Ref WA/48/14/PL

At Deans Yard Orchard Way Fontwell.

Planning Application Reference WA/48/14/PL

Proposed Site Layout

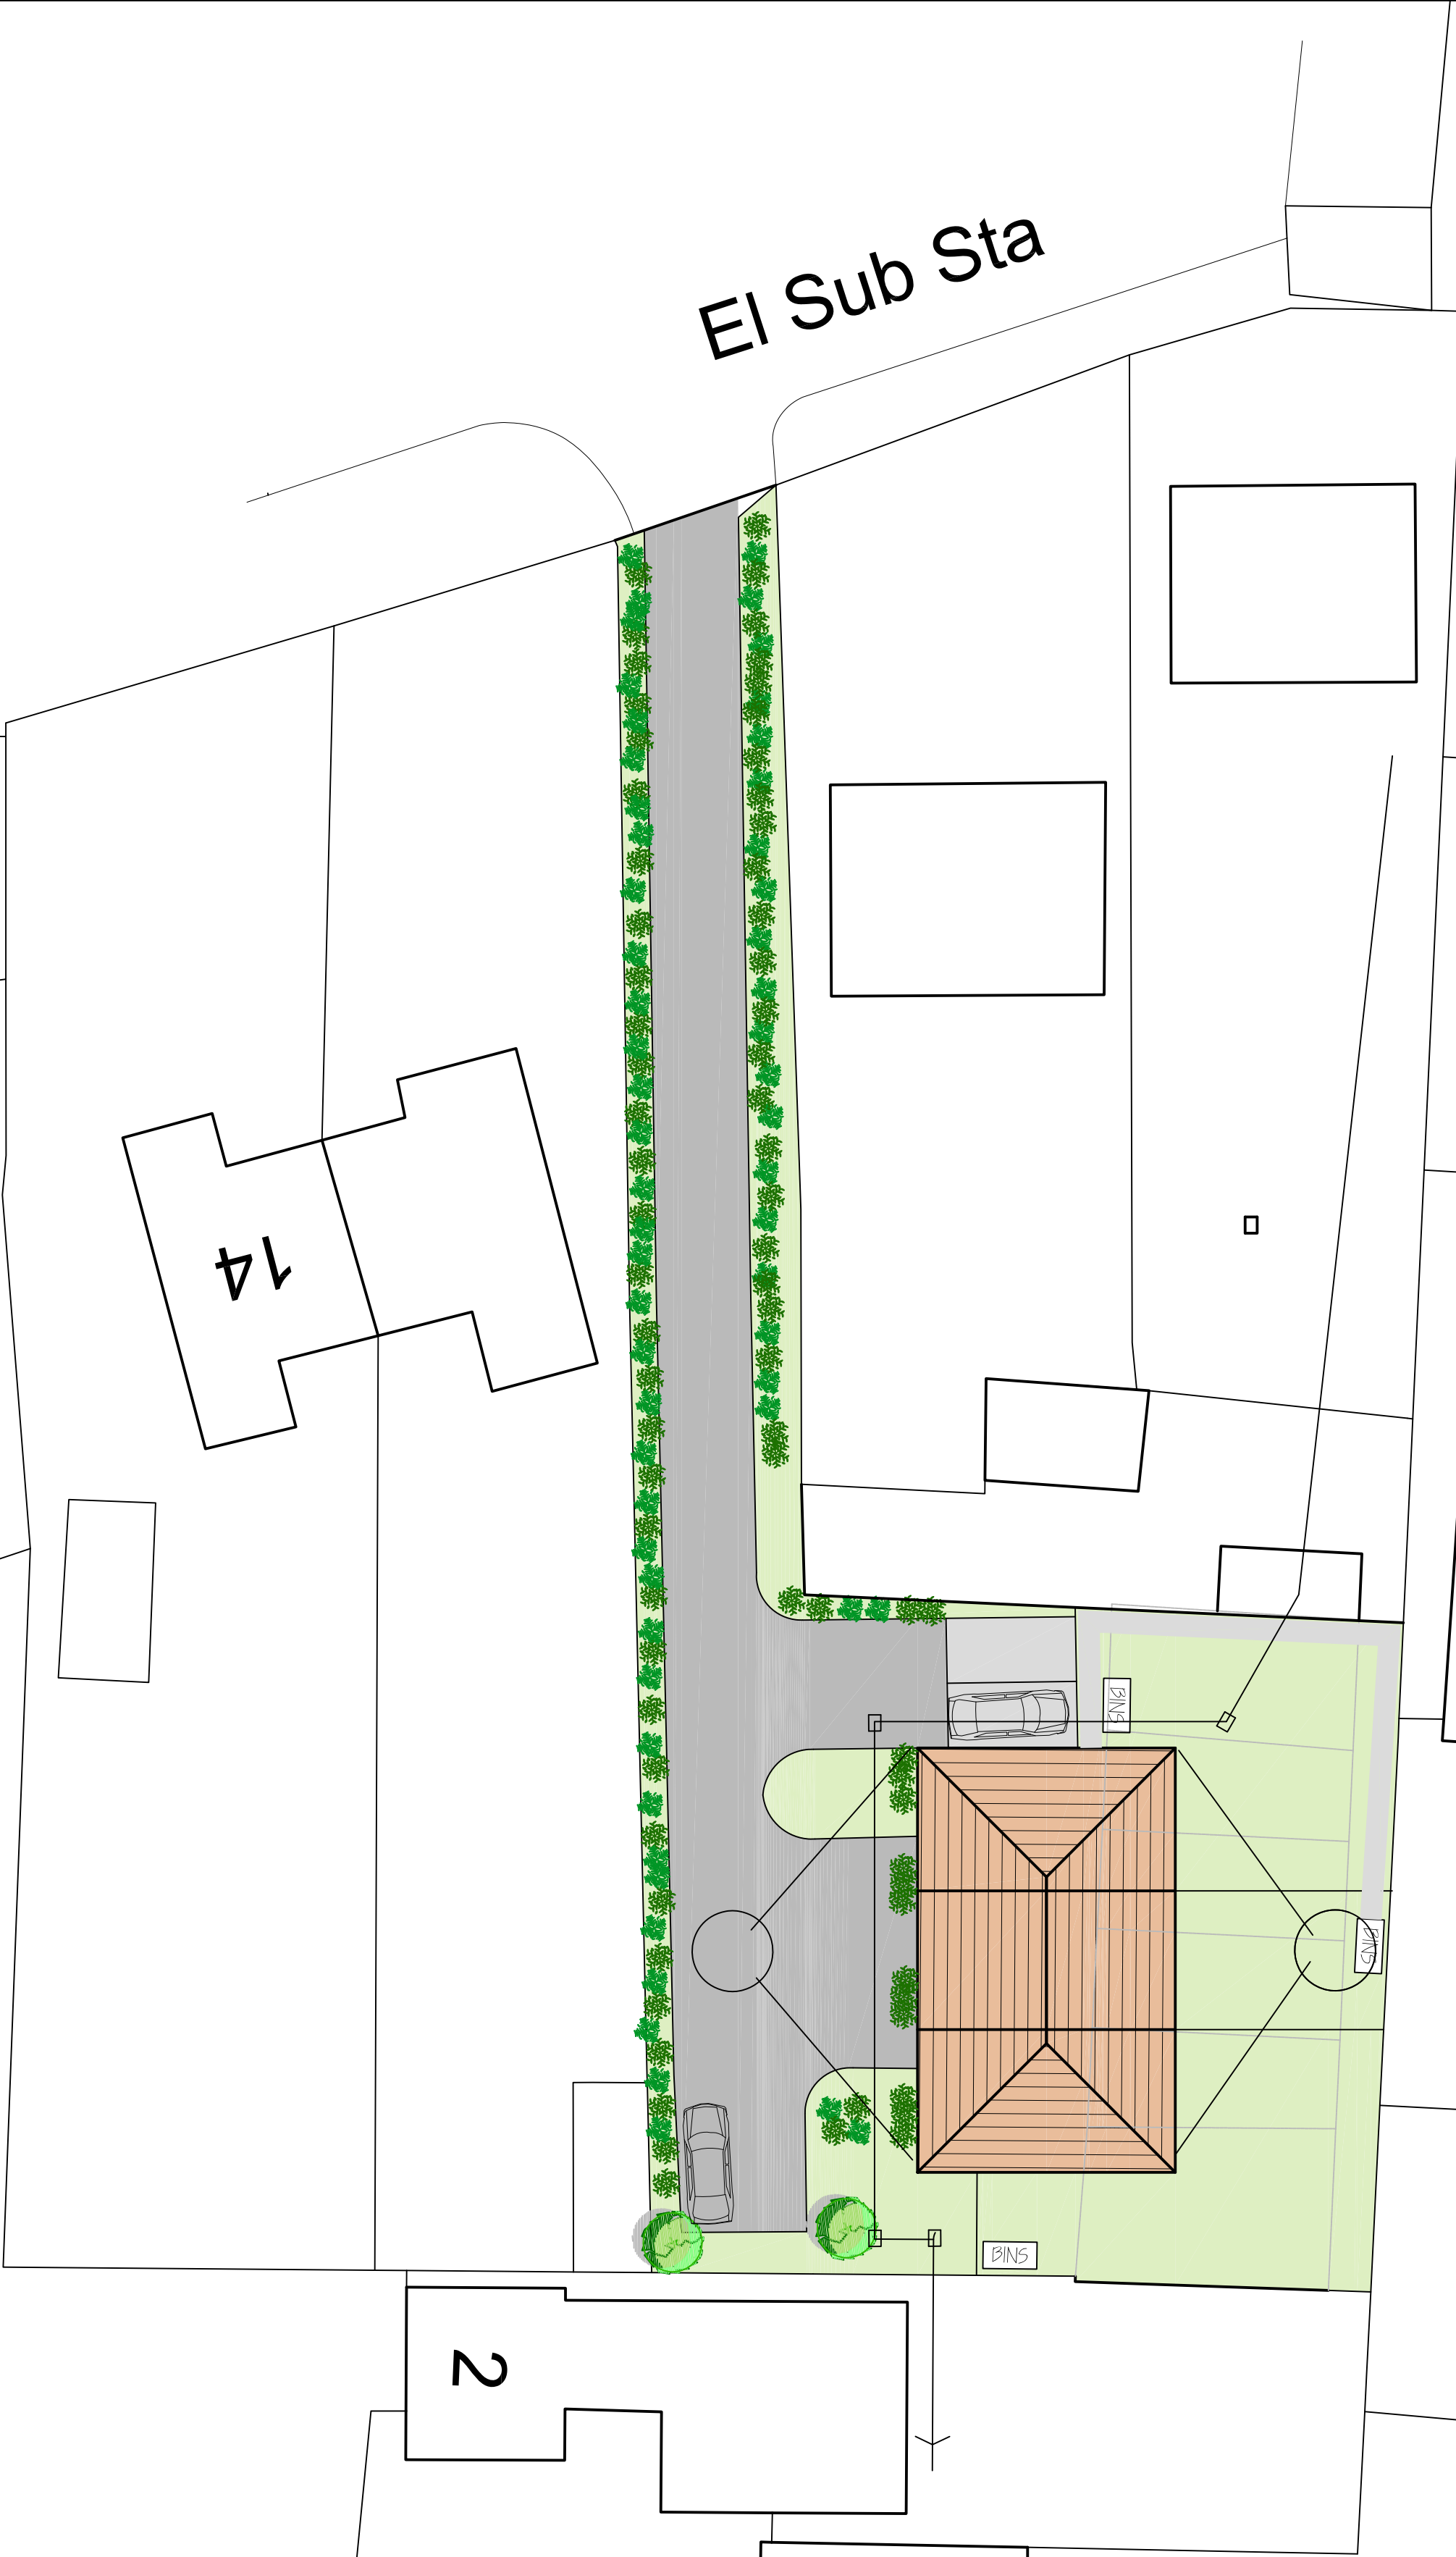
Despite moving the block to a more central position, the dwellings would still be too close to surrounding properties and be overbearing and overshadowing. The provision for parking has been given little thought. With most households these days having two or more cars per dwelling this would equate to six cars for this development. Provision has only been made for four cars and even this is questionable as part of the area allotted for parking is at the end of the access road to Deans Yard, which technically does not belong to the development. This situation also dramatically cuts down the area for access vehicles and turning.

Although a minimal change in the layout of the properties is shown, i.e, bedroom 3 now shows as a study/office. The applicant shows a complete disregard for the access to Deans Yard and subsequent sighting of the new property and parking arrangements.

The applicant clearly assumes that they may "adopt" the land clearly shown as the access road to Deans Yard, which still remains the property of Geoffrey Hudson Dean, as confirmed by the Land Registry on 15.09.14.

I therefore object most strongly to the re-positioning of these properties and subsequent parking arrangements.
